RE: REQUEST FOR ADDITIONAL INFORMATION – SSDA 7388 MOD 10

This submission has been prepared by Ethos Urban on behalf of Grocon (Darling Harbour) Developments (Grocon), in response to the Request for Additional Information (RFI) issued by the Department of Planning and Environment (DPE) on 25 November 2019, relating to SSDA 7388 MOD 10. SSDA 7388 MOD 10 seeks approval for a redesign of the SHFA building, modifications to the Porte Cochere (Ribbon building) form and material finish, modifications to the playground area and reconfiguration of bicycle parking, adjustment of public domain levels at the front of the building to provide stepped levels, and an adjustment of the approved signage zones.

Table 1 Response to DPIE RFI items

DRAWING TITLE
GFA AREA SCHEDULE

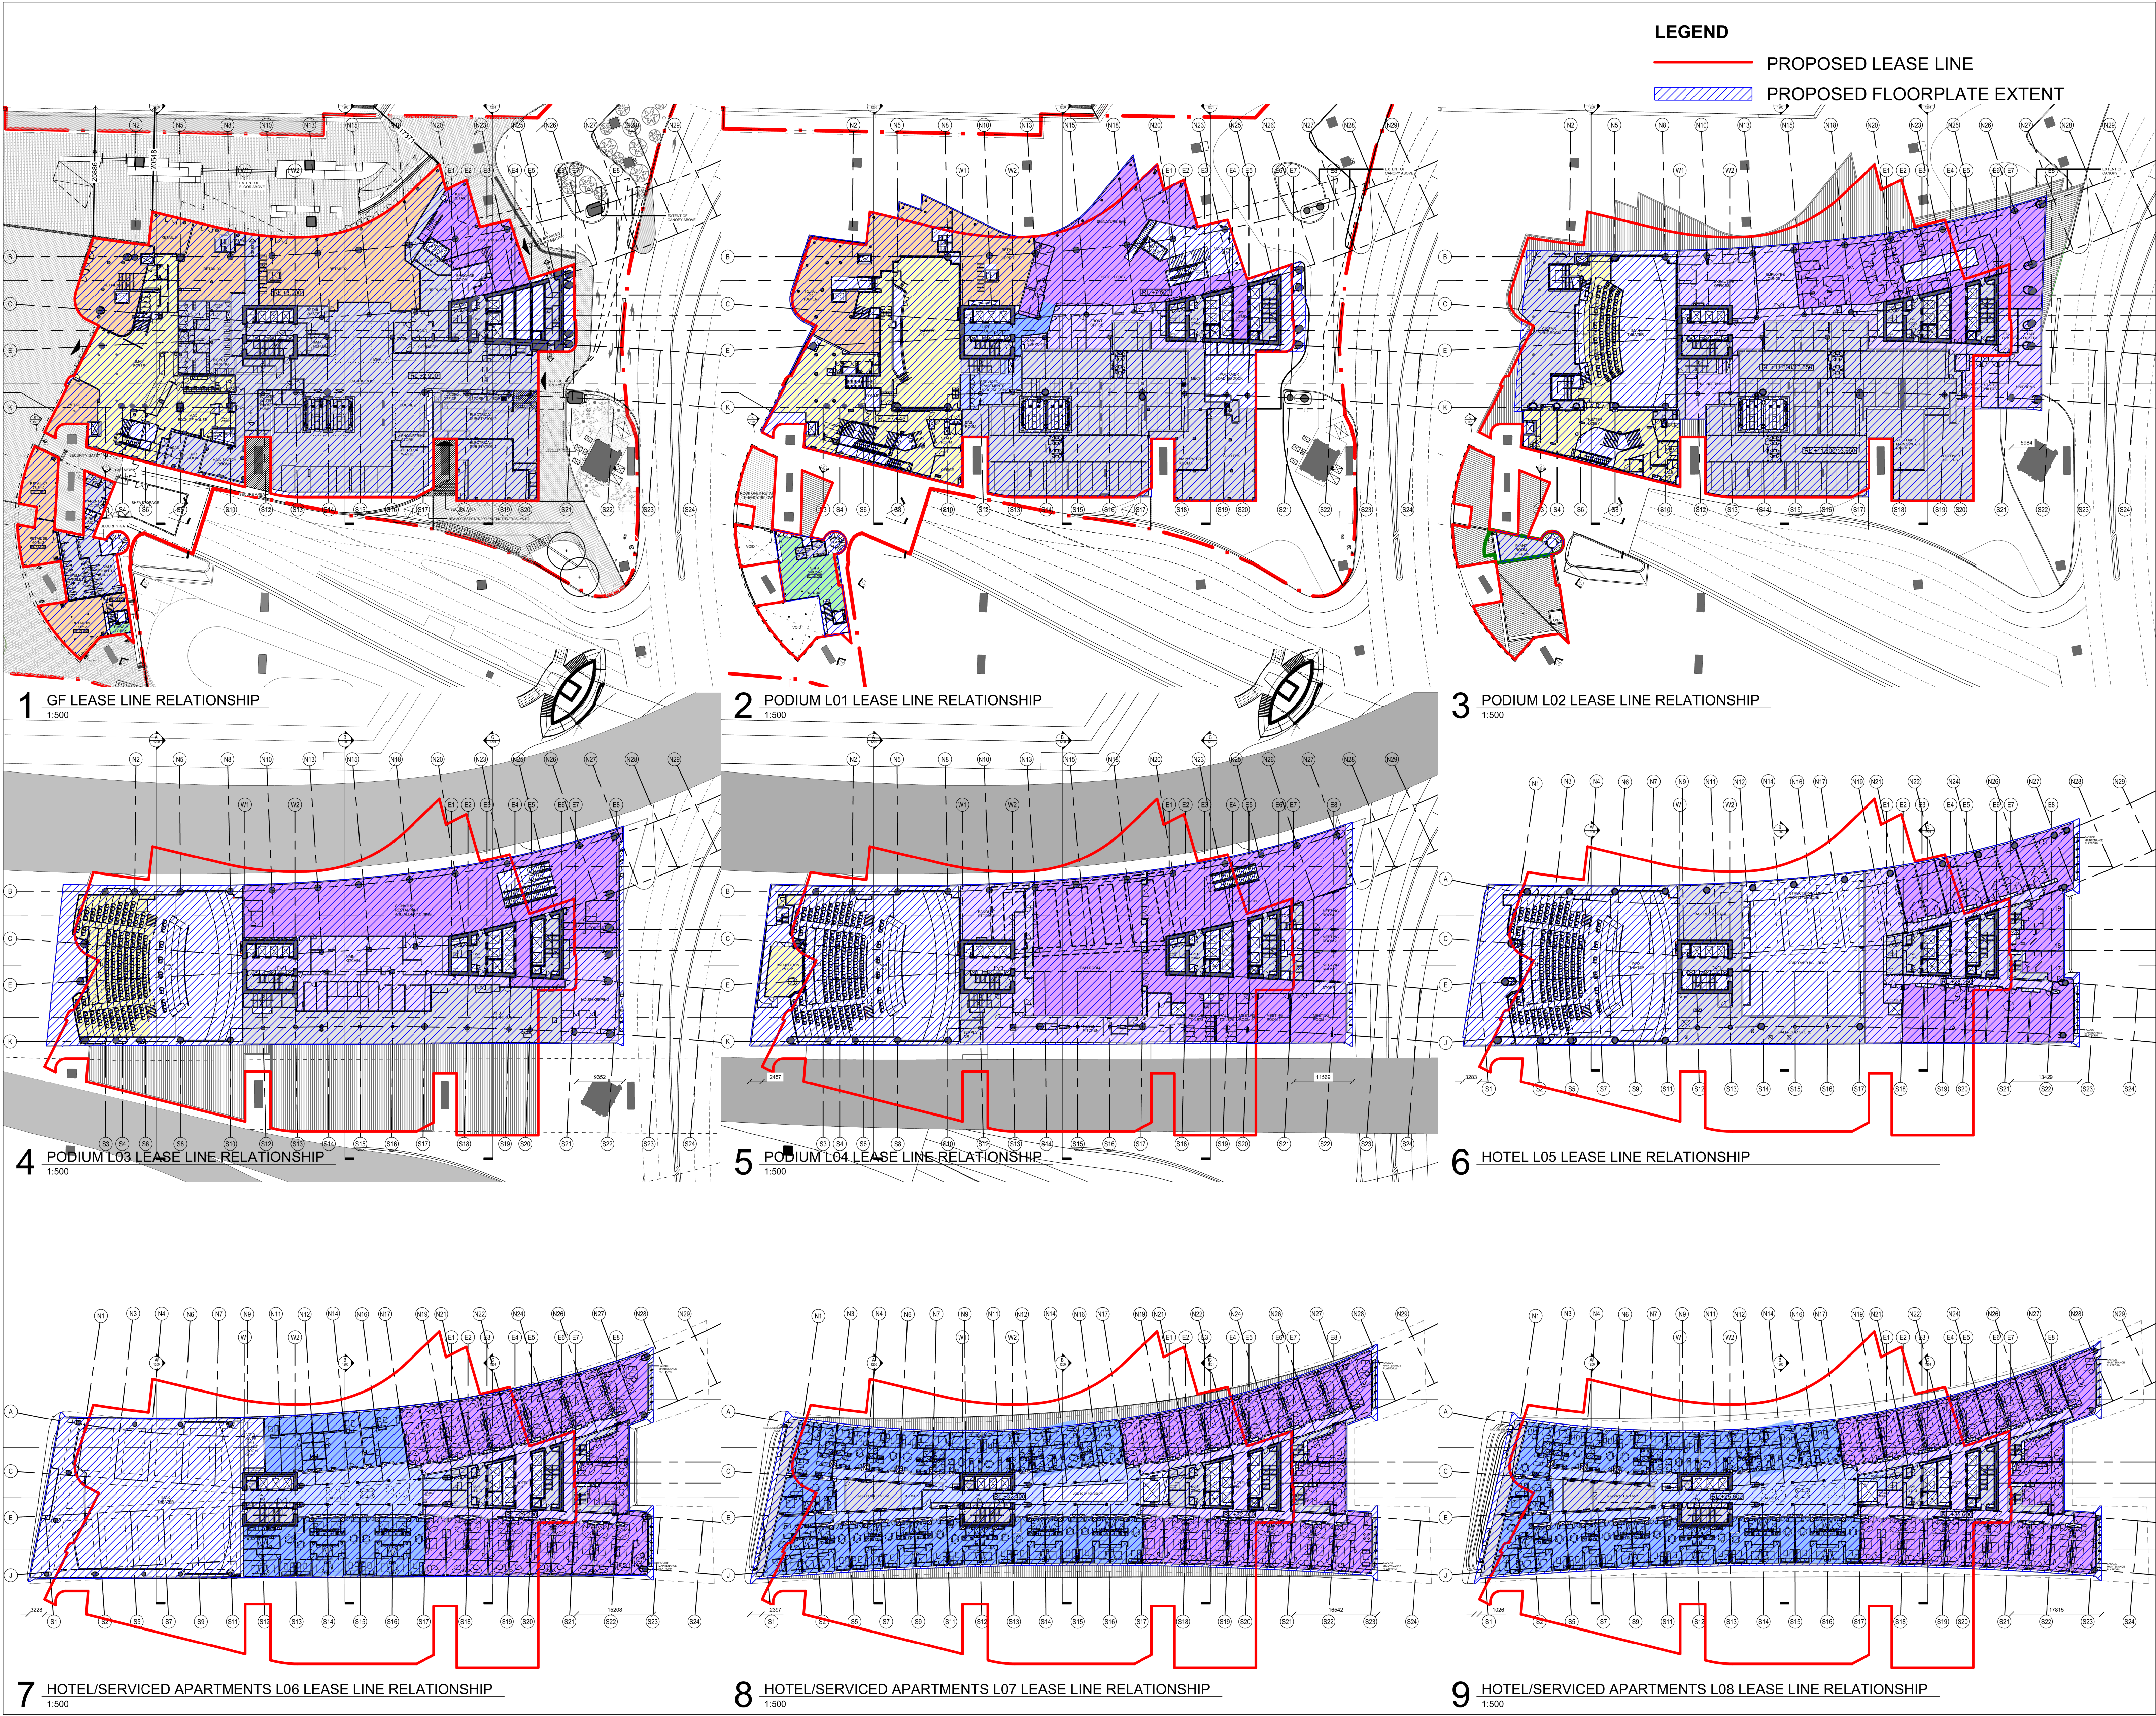
Item and Description	Response
SHFA Building	
<i>The submitted GFA calculations show a reduction in retail GFA, however the Modification Report and submitted floor plans propose an increase in retail GFA. Please clarify how the retail GFA has been calculated and provide a breakdown of the approved and proposed retail GFA for the SHFA building.</i>	Revised Architectural Plans have been prepared by Hassell at Attachment A rectifying the issue raised. A detailed GFA breakdown has been provided, there is a slight increase in the area of the retail contained within the SHFA building.
<i>The proposed elevations and sections of the SHFA building reference existing structures and materials despite all buildings on site having been demolished. Please provide clarification and amended elevations as necessary.</i>	The SHFA building has not been demolished and is still in operation as of the submission of this modification. The SHFA building is to be redeveloped at a later stage as part of SSD 7388 with some of the existing building structures to be reused and adapted.

General Building Envelope Materials Matrix

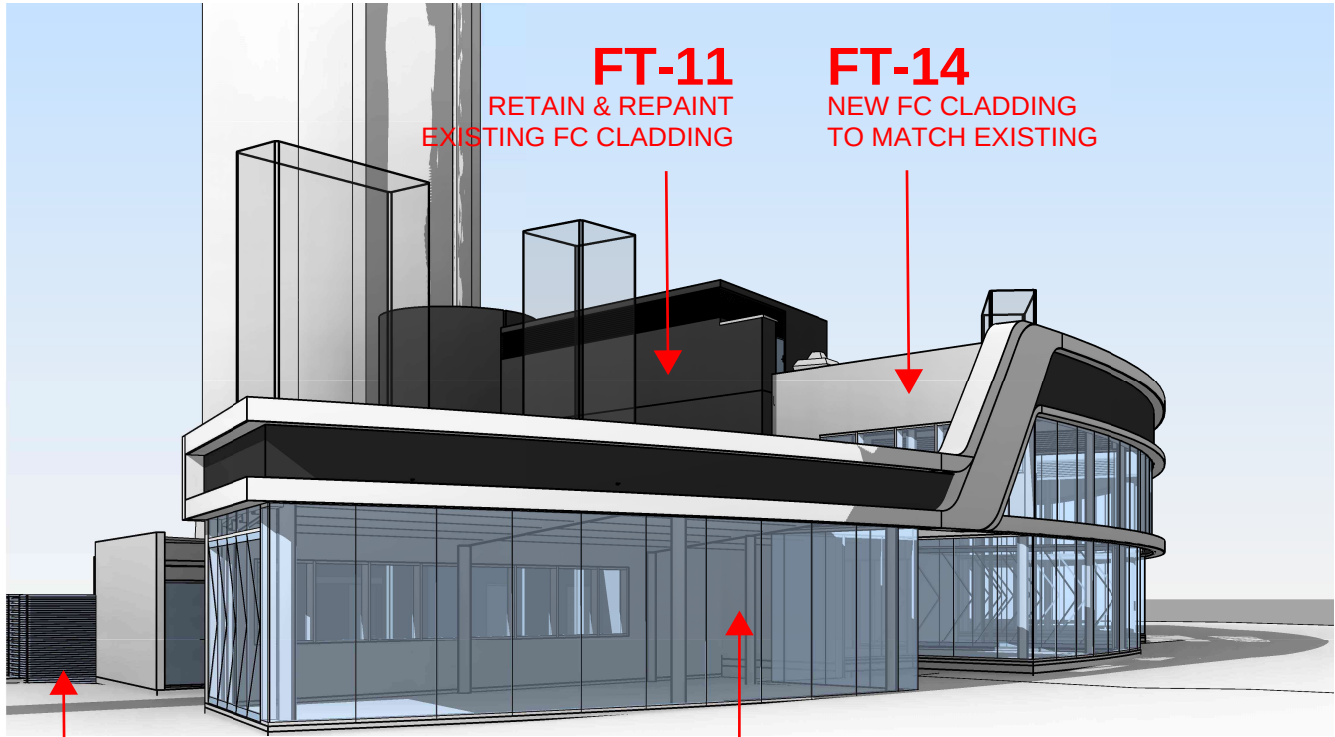
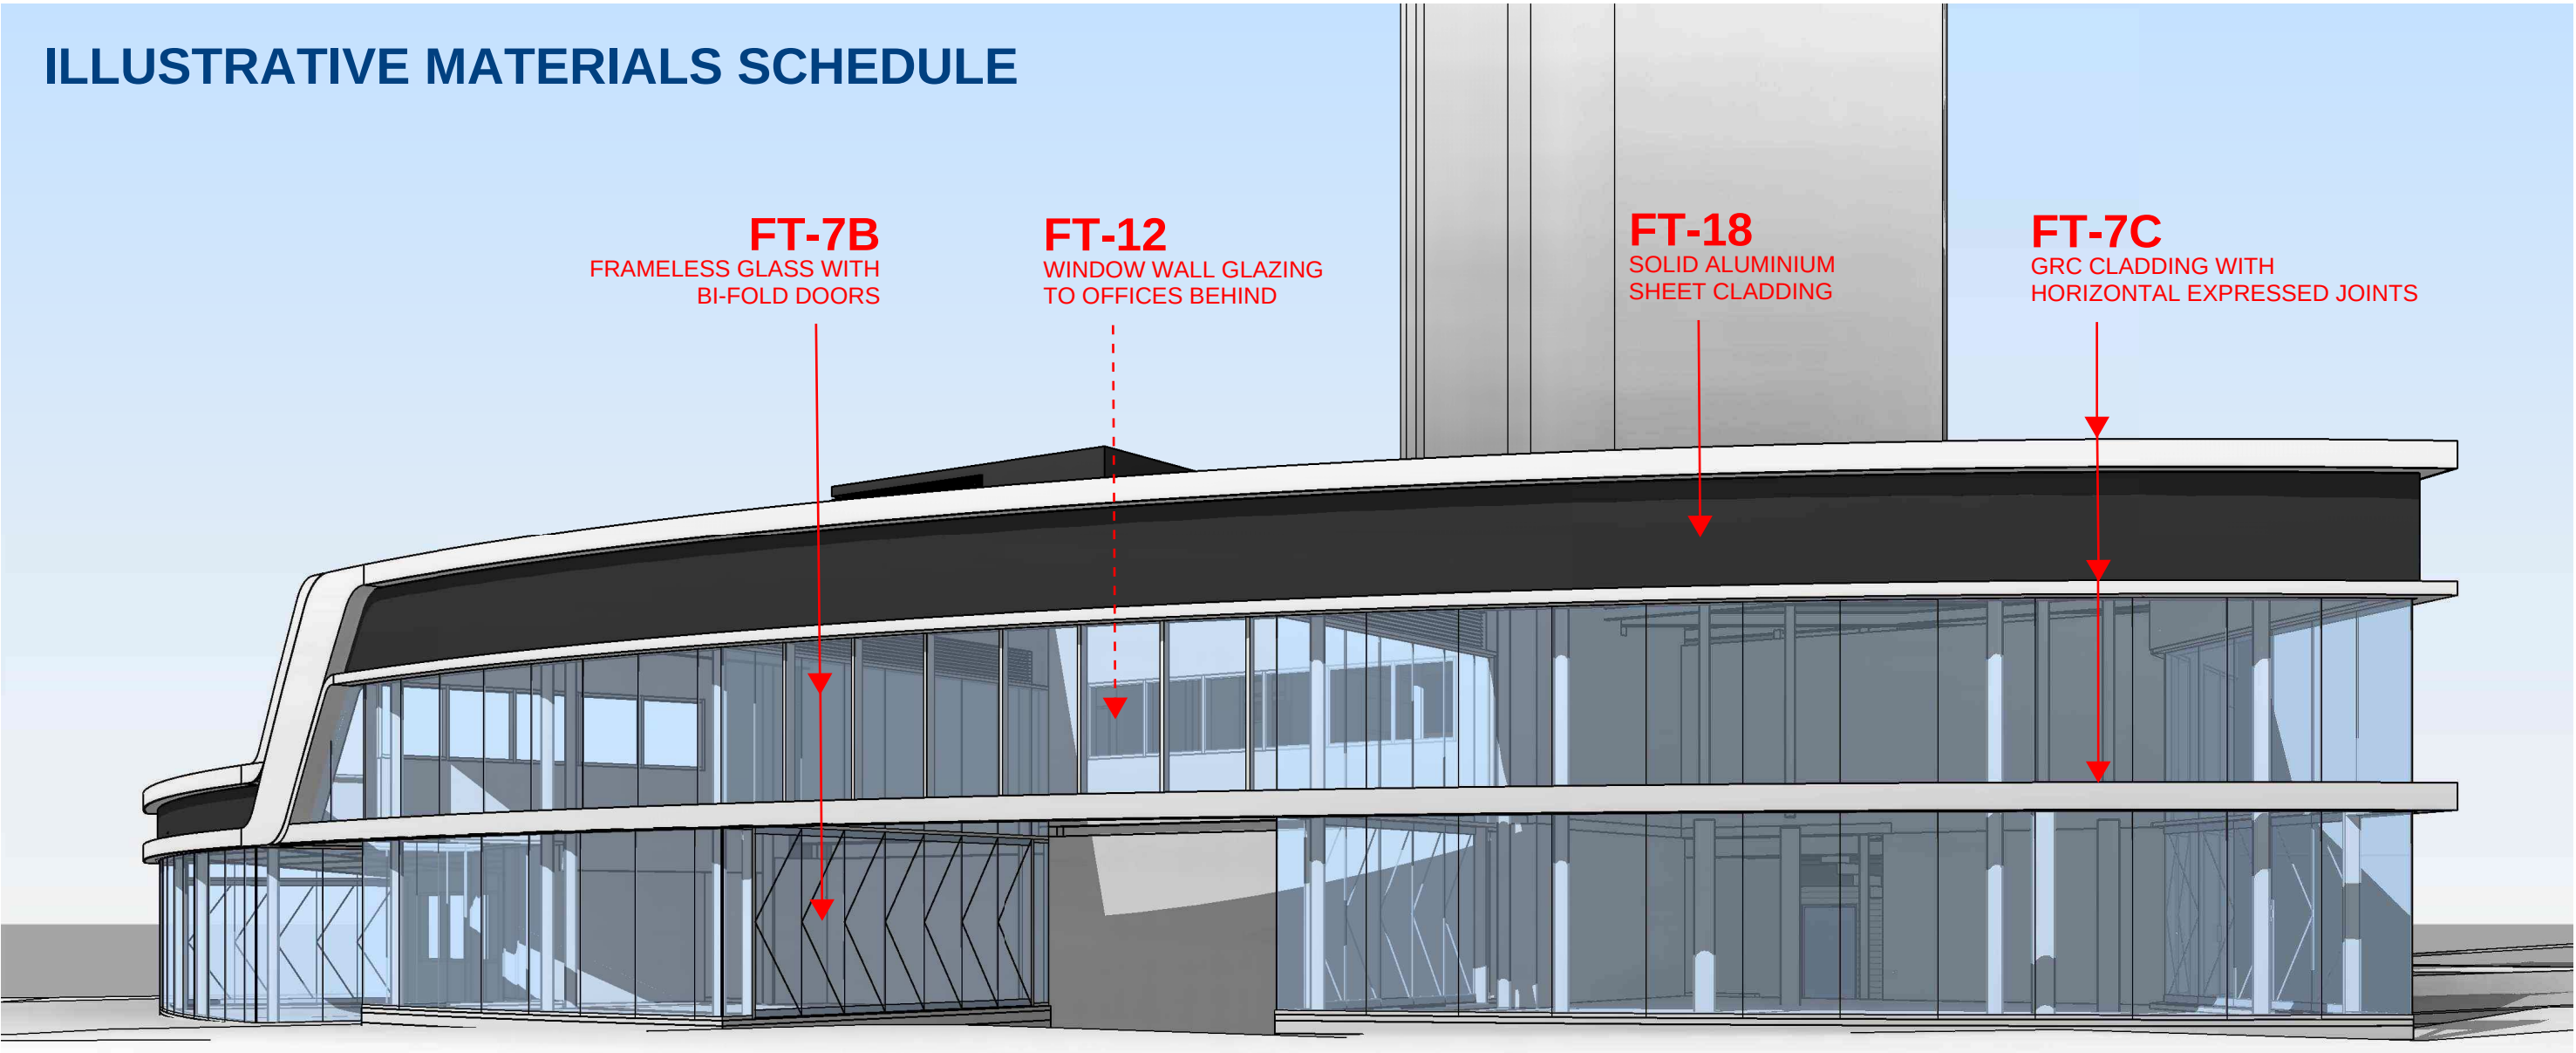
<i>The proposed materials matrix (dated 19 June 2019 Revision D) indicates the reflectivity of materials has increased from 8% to 20%. Please amend this table to reflect the approved reflectivity or provide justification for the proposed increase in reflectivity and any changes to the proposed materials.</i>	The materials matrix has been updated and the reflectivity of materials has been reduced back to 8%, refer to Attachment A2 .
<i>Provide an illustrated materials schedule for the SHFA building.</i>	Revised Architectural Plans have been prepared by Hassell at Attachment A with an illustrated materials schedule for the SHFA building provided.
Public Domain	
<i>The public domain plans listed at page 20 of the Modification Report are not consistent with the submitted plans. Please review the listed and submitted plans to ensure consistency.</i>	The revision numbers for the public domain plans provided at page 20 of the Modification Report were erroneous. Notwithstanding the above, revised Public Domain Plans have been prepared by Aspect Studios at Attachment B and supersede those originally submitted with the application.
